PRELIMINARY DRAINAGE REPORT

GRANDVIEW RESERVE FILING NO. 1

El Paso County, Colorado

DATE:
December 10, 2021

EXISTING CONDITIONS - DRAINAGE MAP

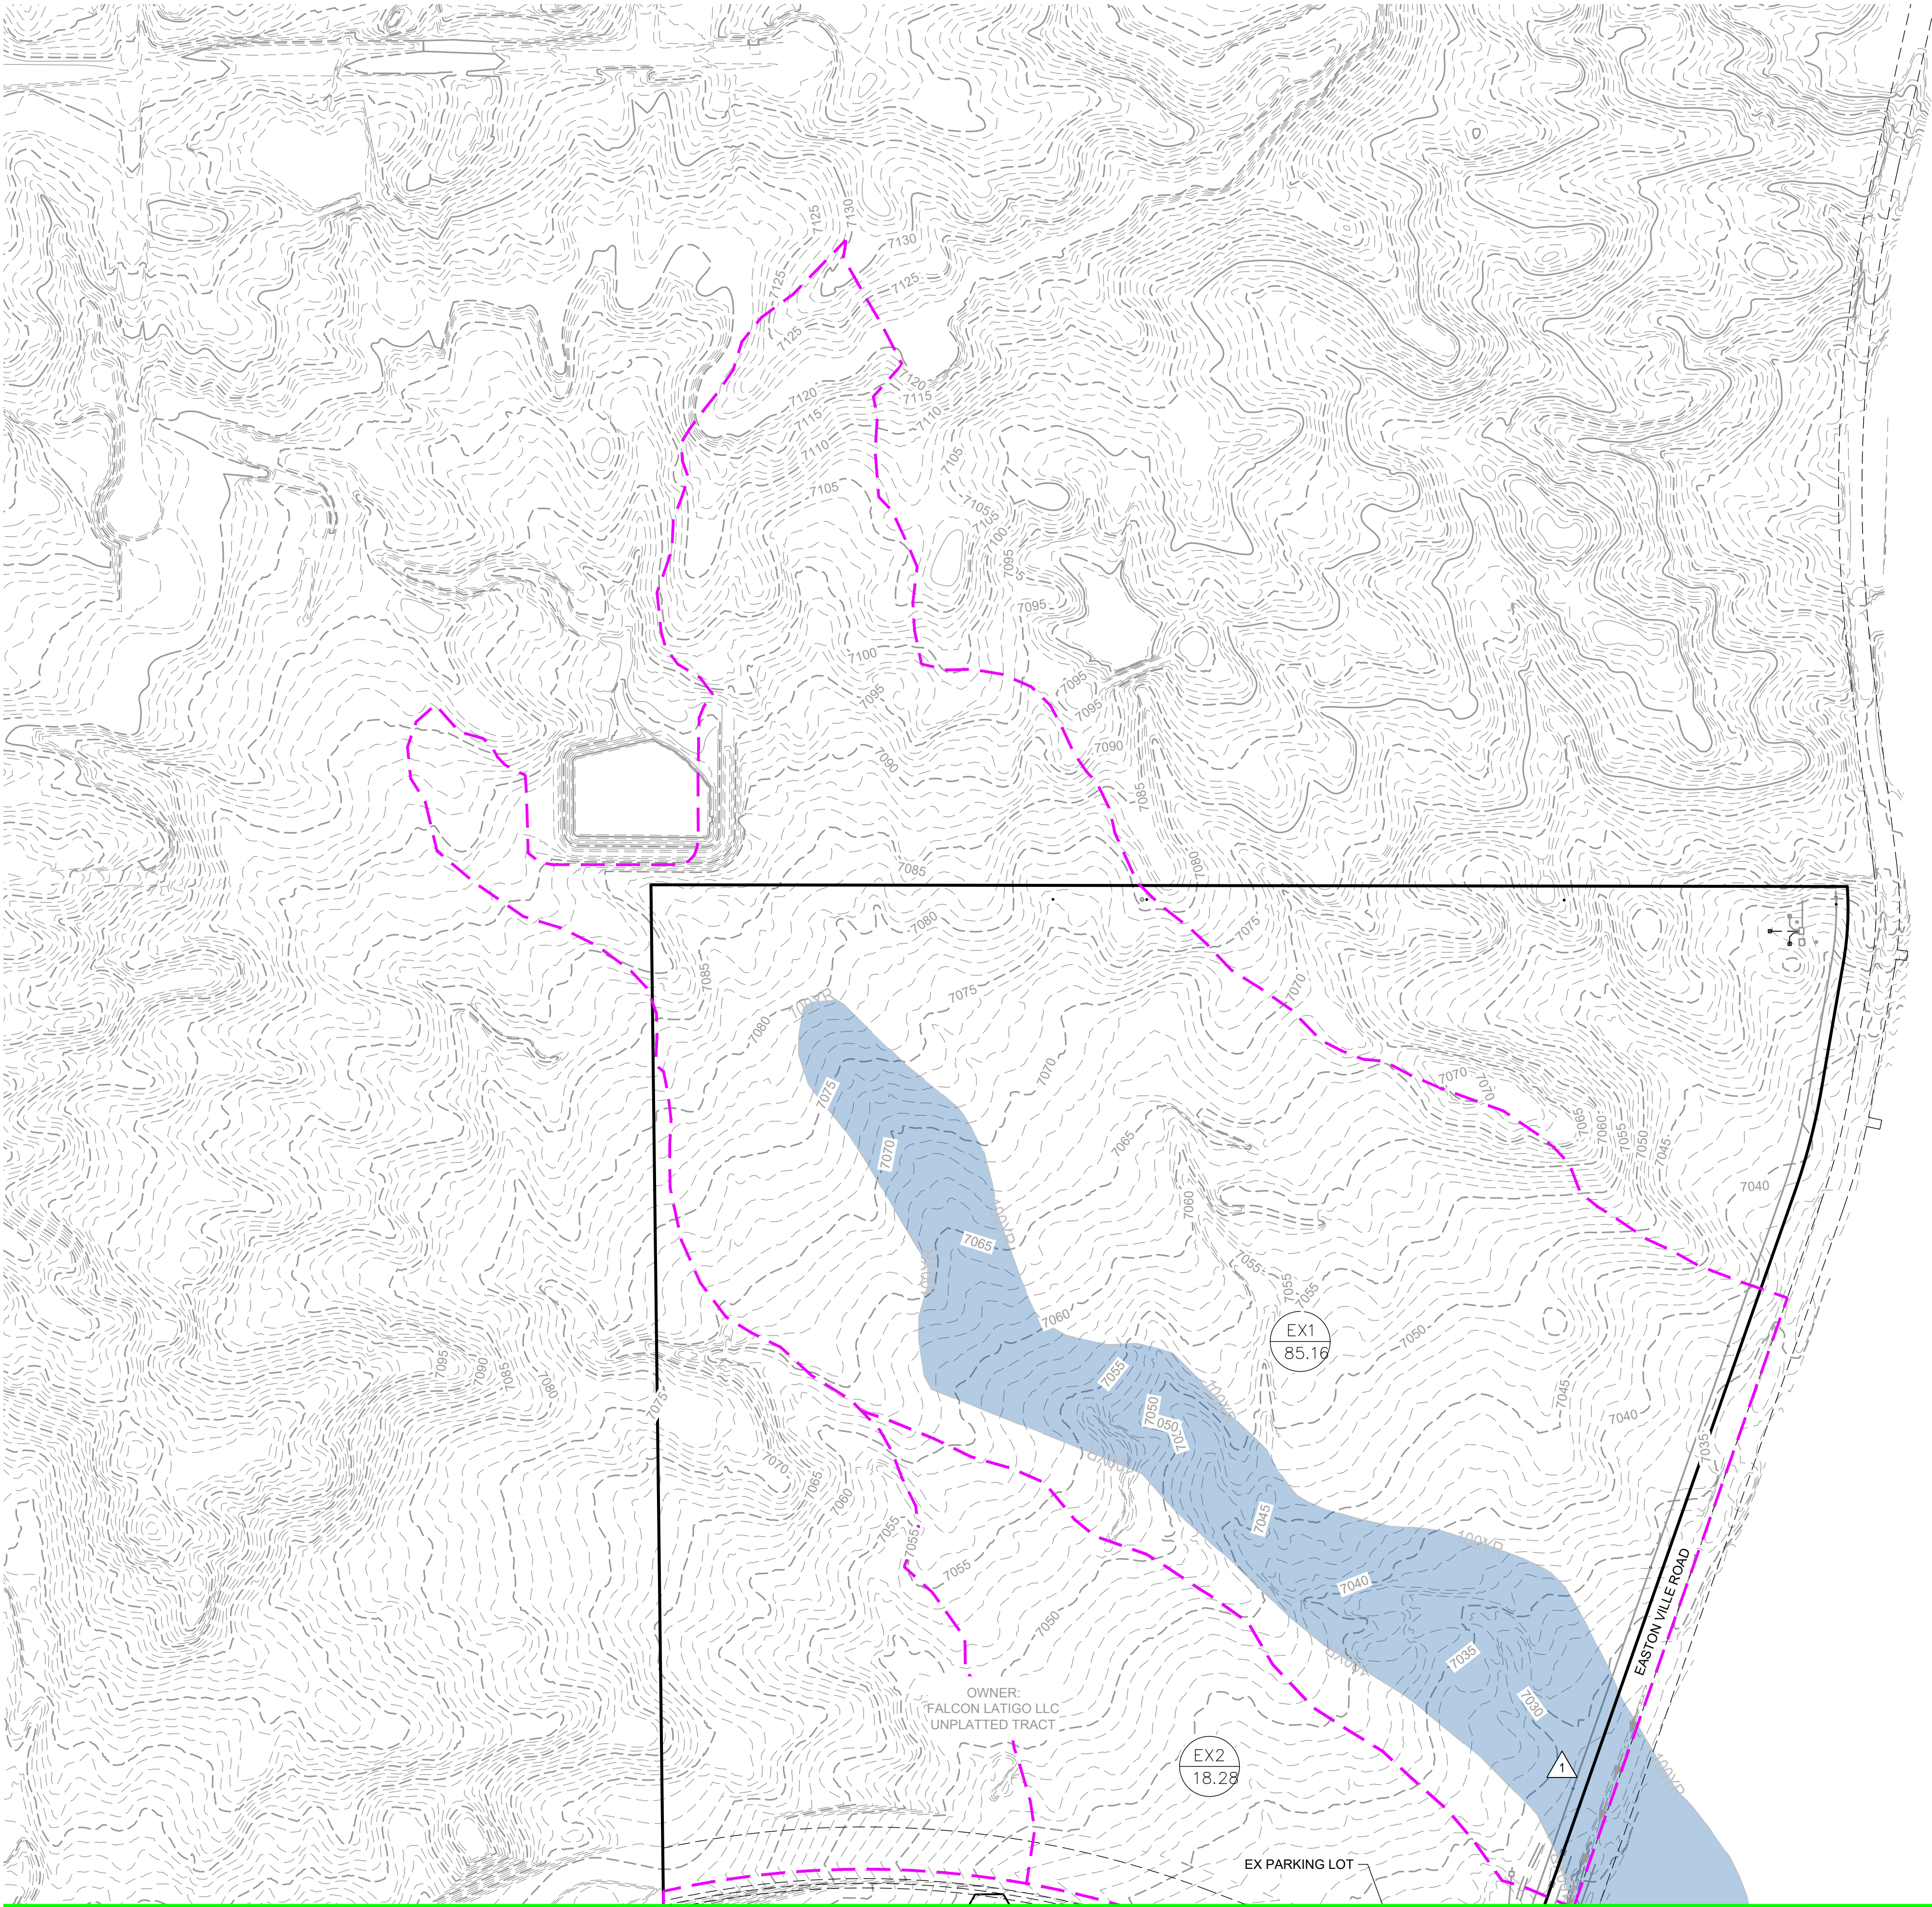
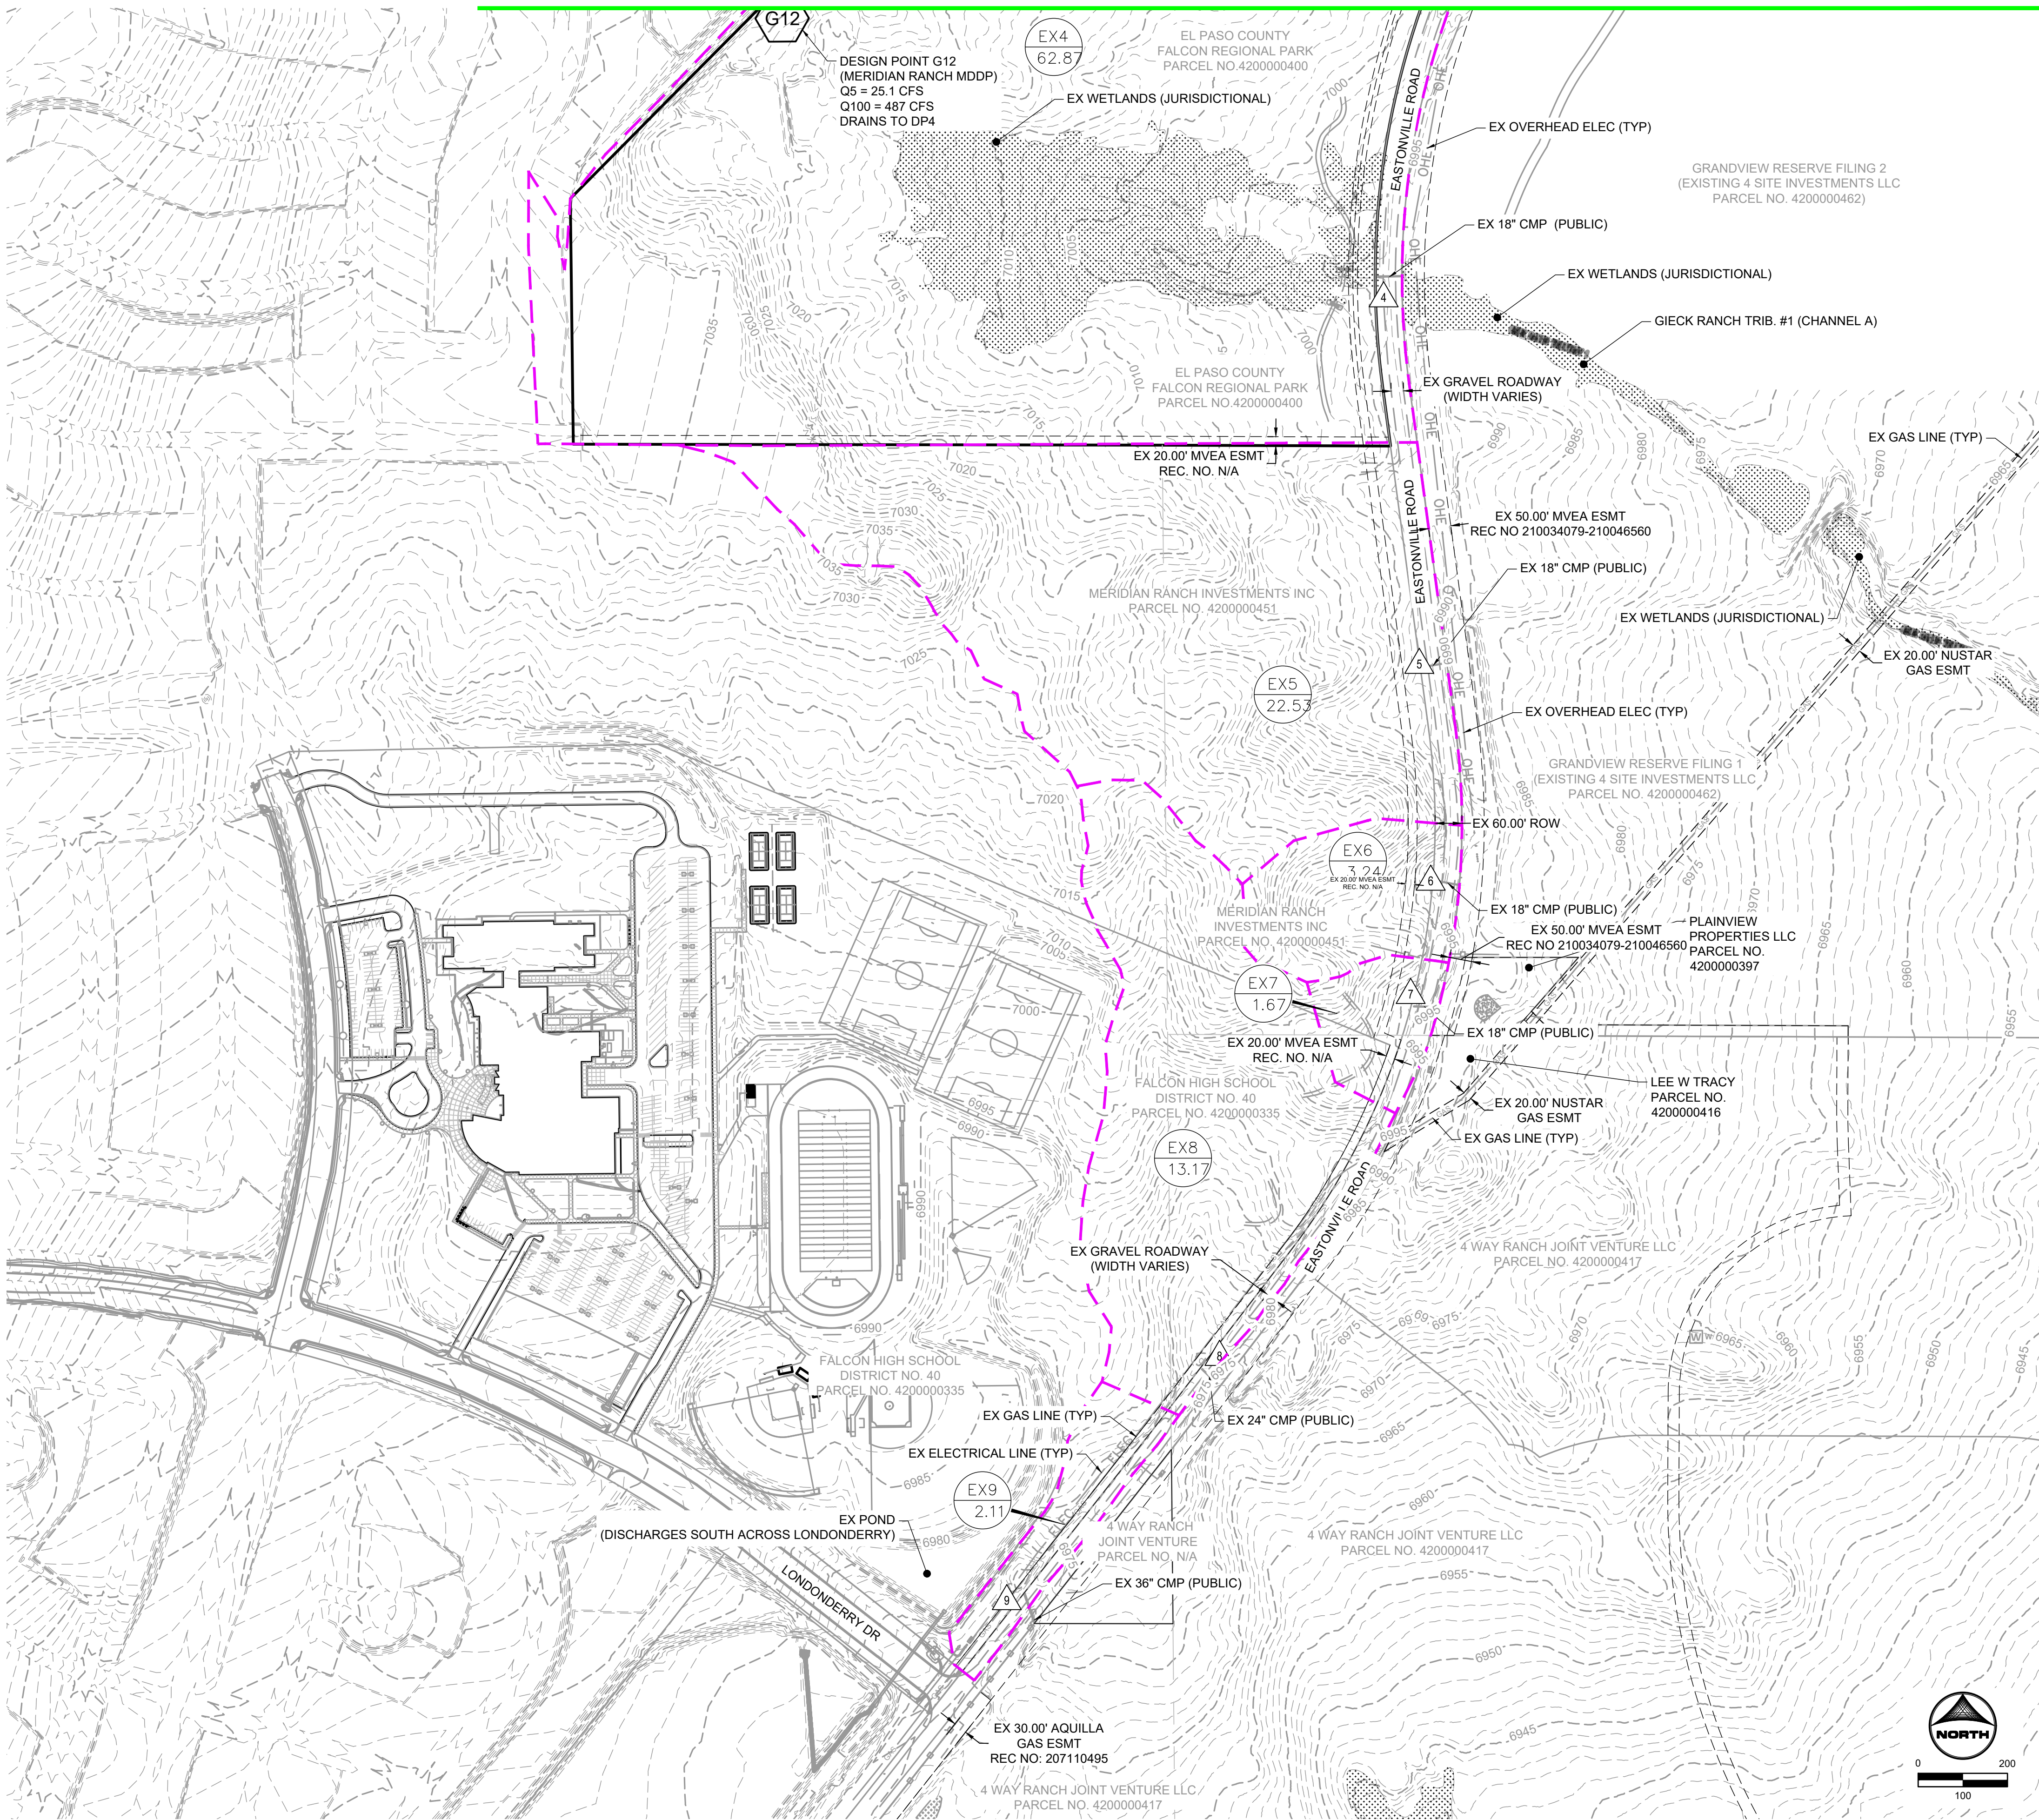
↑ There should be at least 7 onsite and offsite existing basins - break these up as appropriate. See Existing Condition plan redlines.
